Our ref: HA/2011/112481/05-L01
Your ref: BE/84/12/DOC
Date: 28 June 2012

**APPLICATION FOR APPROVAL OF DETAILS RESERVED BY CONDITION 11
OF PREVIOUSLY APPROVED BE/122/08
DEMOLITION OF EXISTING BUILDINGS AND ERECTION OF CLASS A1
SUPERSTORE WITH ASSOCIATED CAR PARKING, LANDSCAPING, PETROL
FILLING STATION, CAR WASH AND JET WASH AND CREATION OF NEW
ACCESS FROM A29 AND INTERNAL ESTATE ROADS TOGETHER WITH
REPLACEMENT CAR DEALERSHIP FACILITY FRONTING SHRIPNEY ROAD
LAND AT LEC SITE SHRIPNEY ROAD BOGNOR REGIS PO22 9NQ**

At present we are currently unable to recommend the discharge of planning condition 11.

Development Proposals

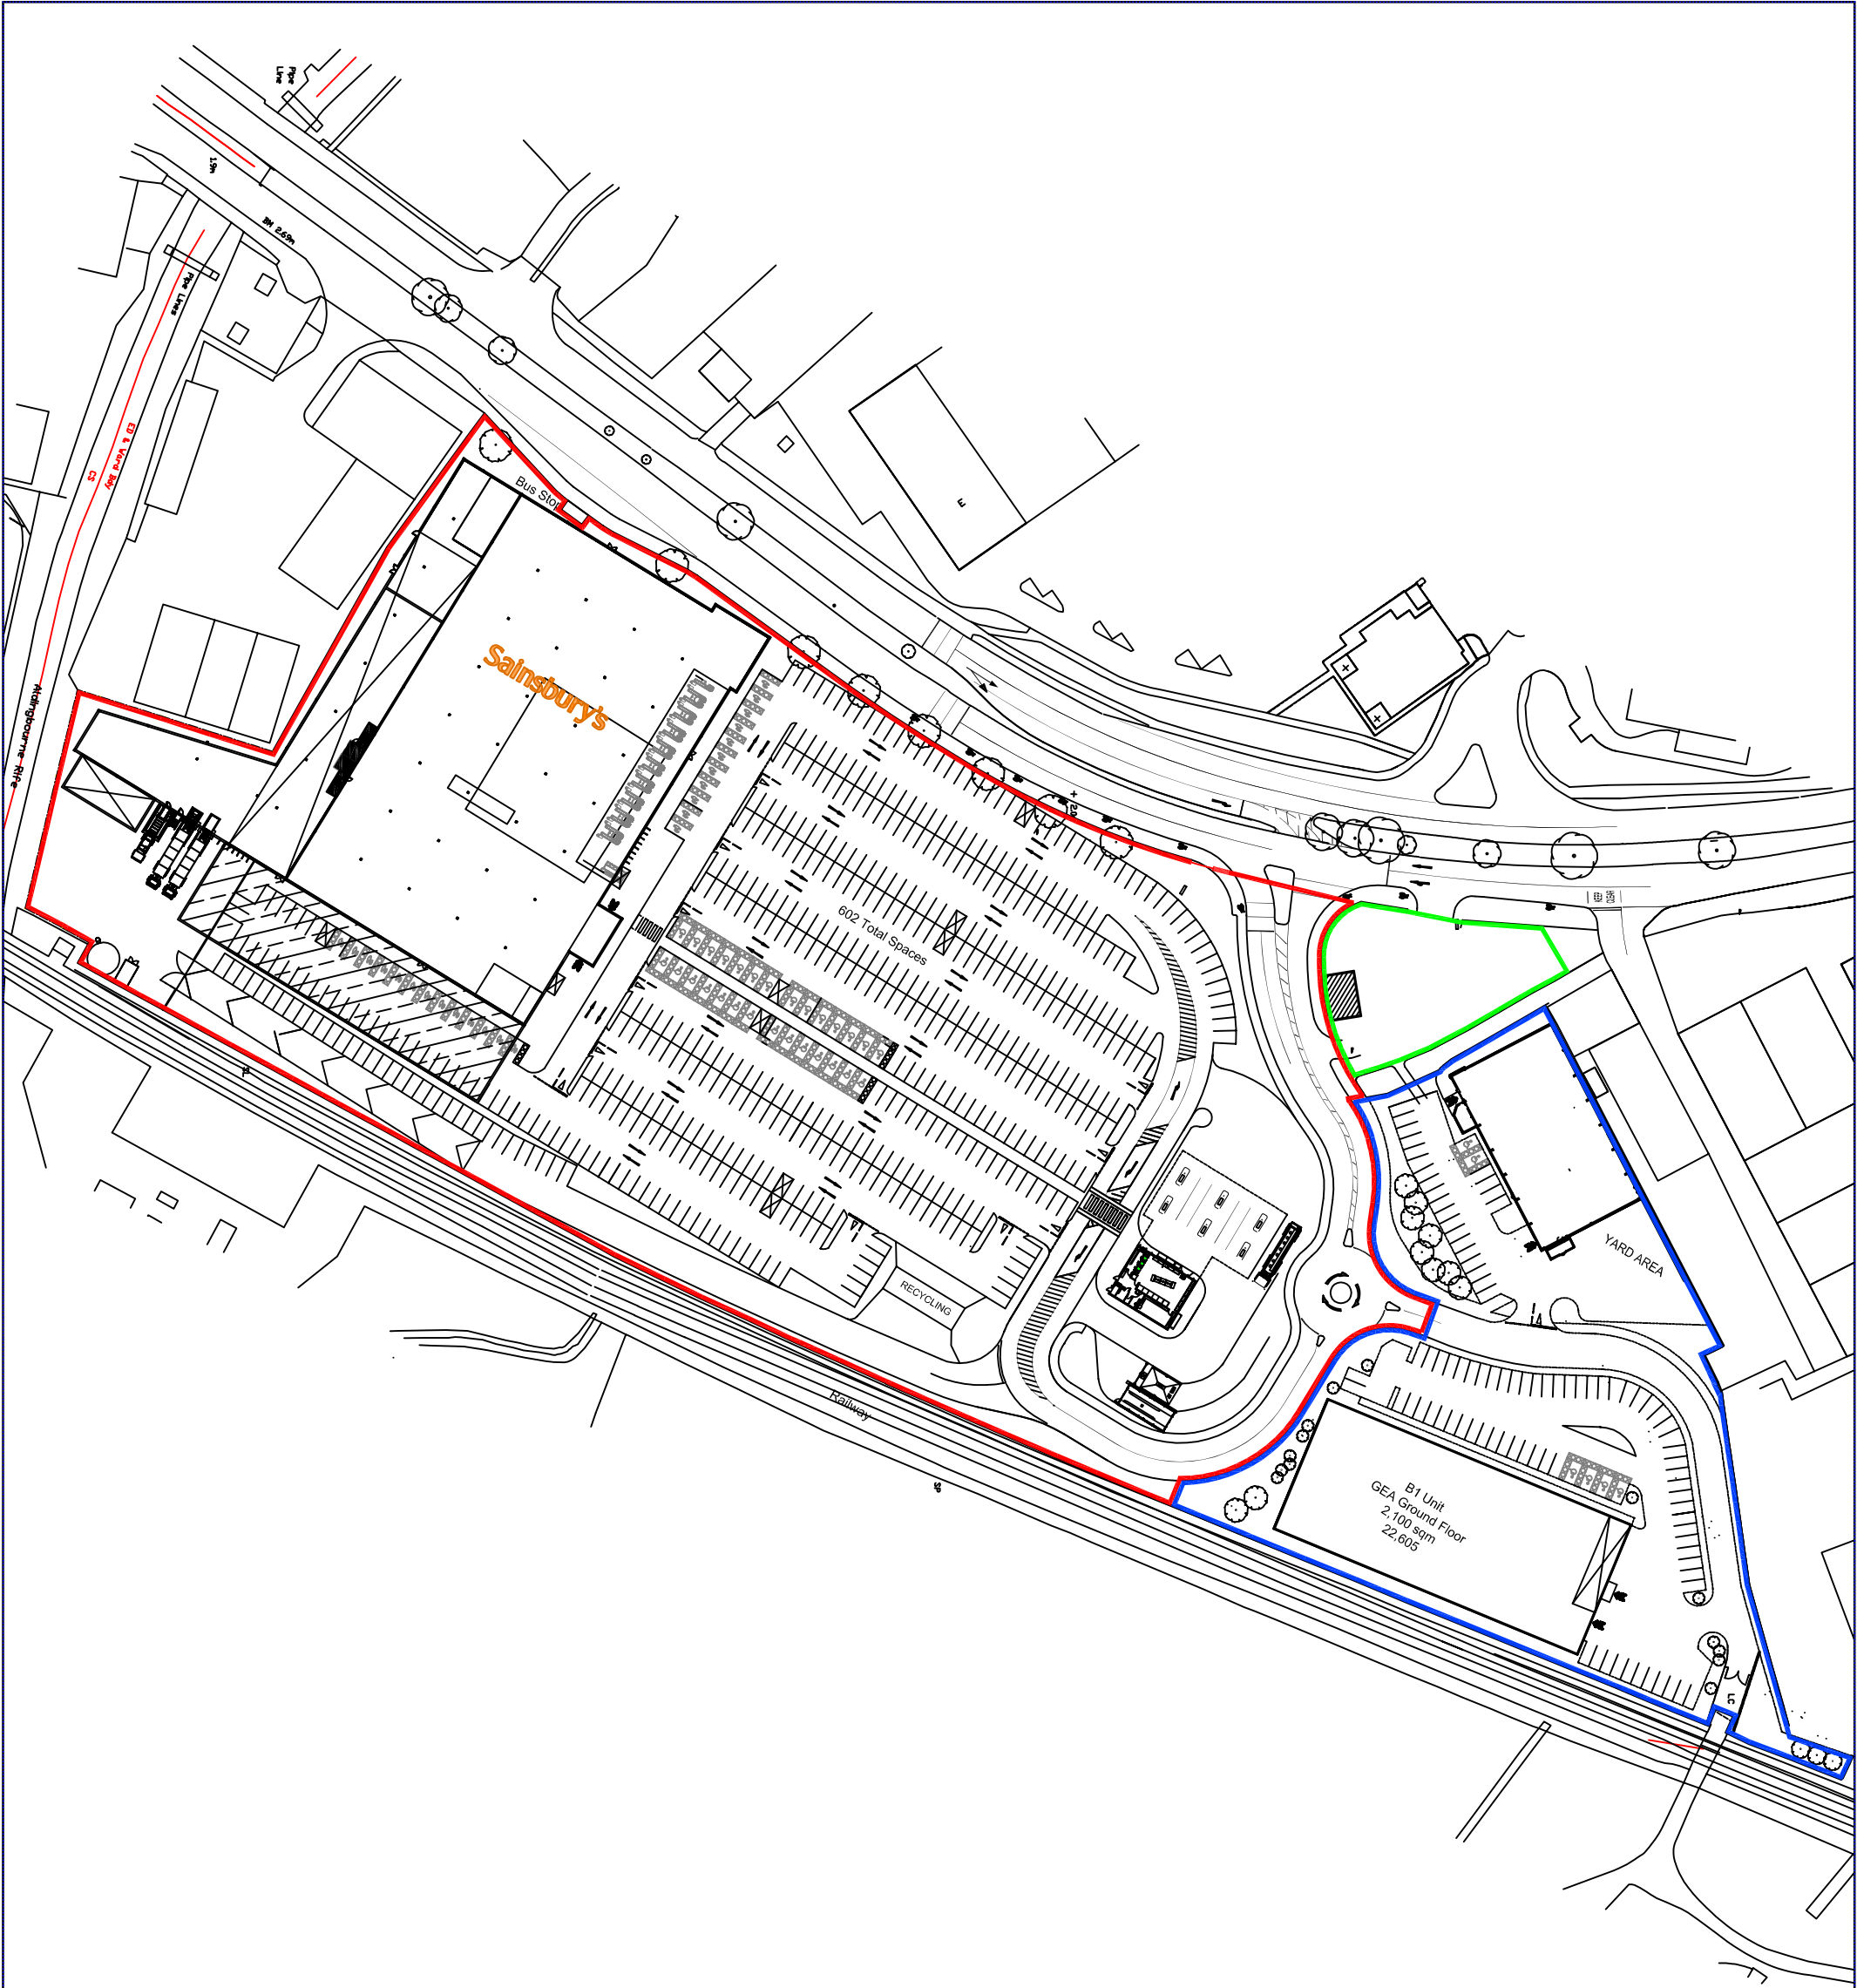
The drawings show that it is intended to pump surface water for a section of the site to the proposed outfall location. Pumping surface water is not a sustainable solution given the energy requirements for this, and the likelihood of failure. In addition, the ground levels indicate this section of the site could easily be drained via gravity to the Aldingbourne Rife, and no justification of why this is not possible has been given.
